From: Ian Gledhill [REDACTED]
Sent: 28 January 2021 14:30
To: Amy Myer <Amy.Myer@arun.gov.uk>
Cc: Claire Potts <Claire.Potts@arun.gov.uk>; James Cross <James.Cross@arun.gov.uk>; Steven Shaw [REDACTED]
Subject: RE: BE/148/20/OUT - Nursery Fields - Link Road - URGENT QUERY

SITE ACCESS PLAN (REF: ITB14244-GA-009)

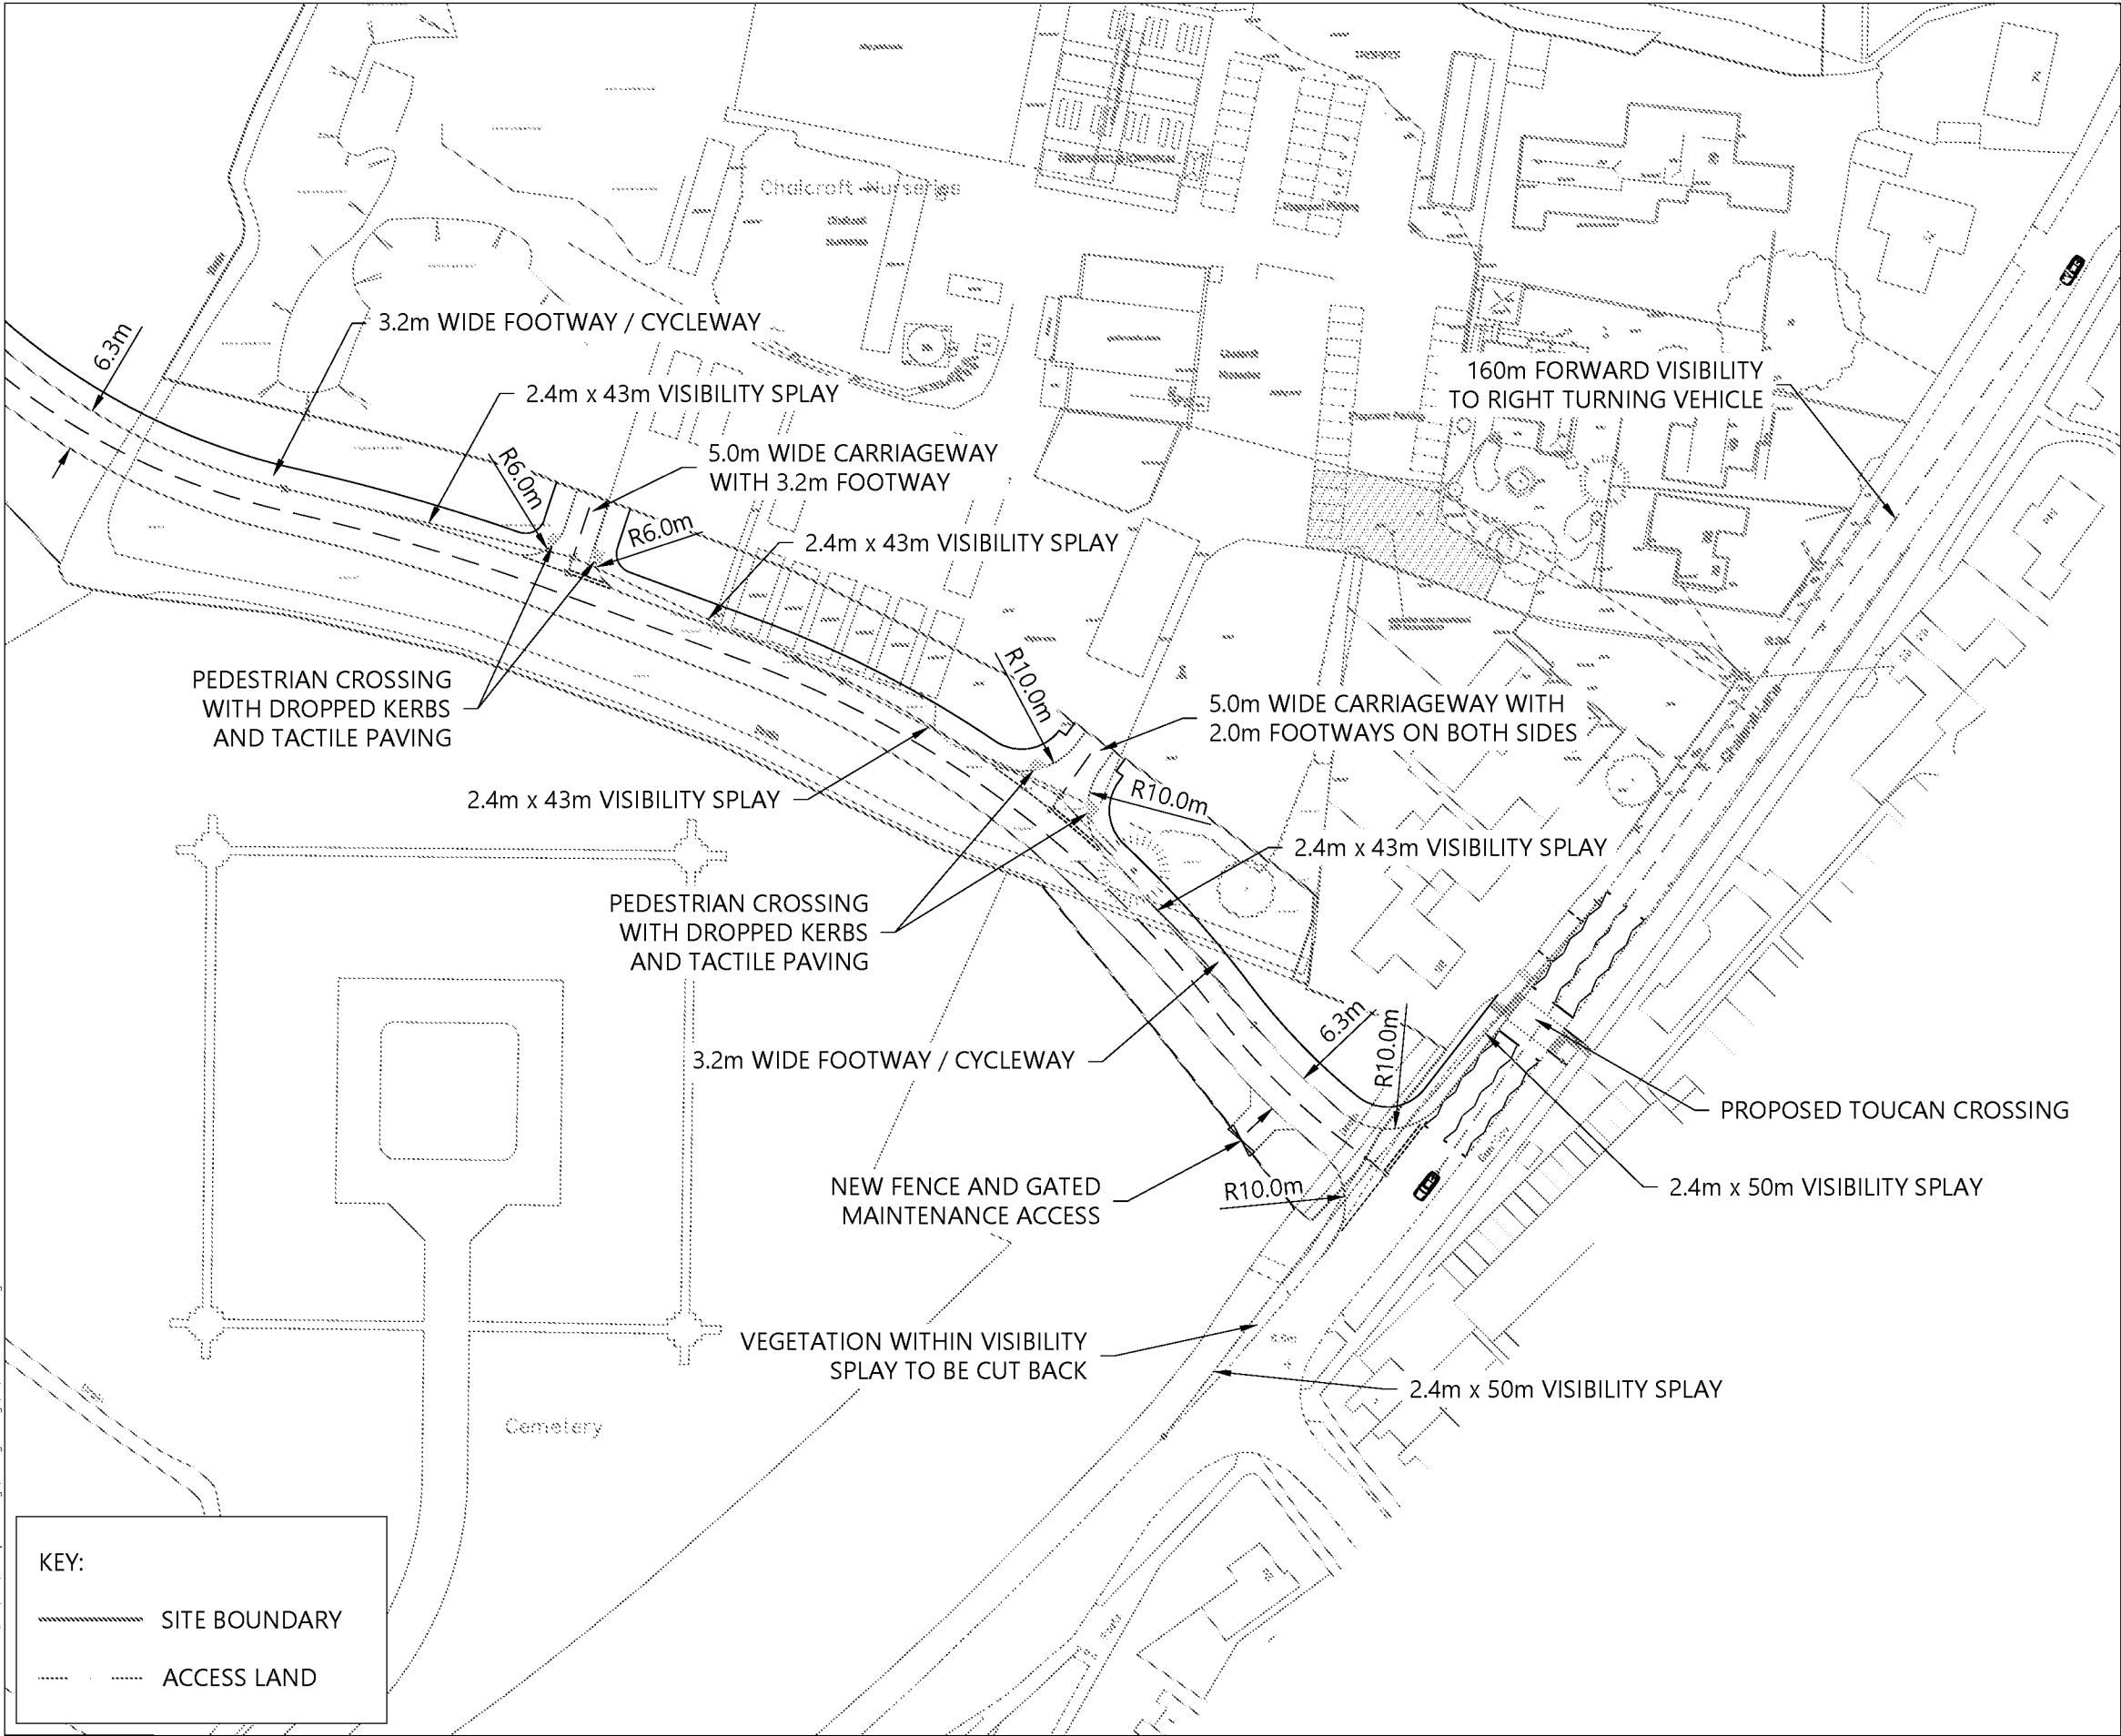
Hello Amy, in short, additional modelling would be required if a further through route was to be created from Chalcraft Lane. The agreed model scope (which has been agreed between WSCC and Pell Frishman) at present considers a single vehicular access onto Chalcraft Lane south of West Meads Drive. If a new through route were to be created further north via the Chalcraft Nursery application site, the modelling would need to be revised to account for the potential redistribution of traffic.

I'm not sure exactly how a northbound one way would work in practice or at which point the one way would start. Such an approach may be quite complicated to implement and would require a traffic order. I'd suggest any modelling should assess a two way access. A one way system should only be looked at if the modelling indicates a need.
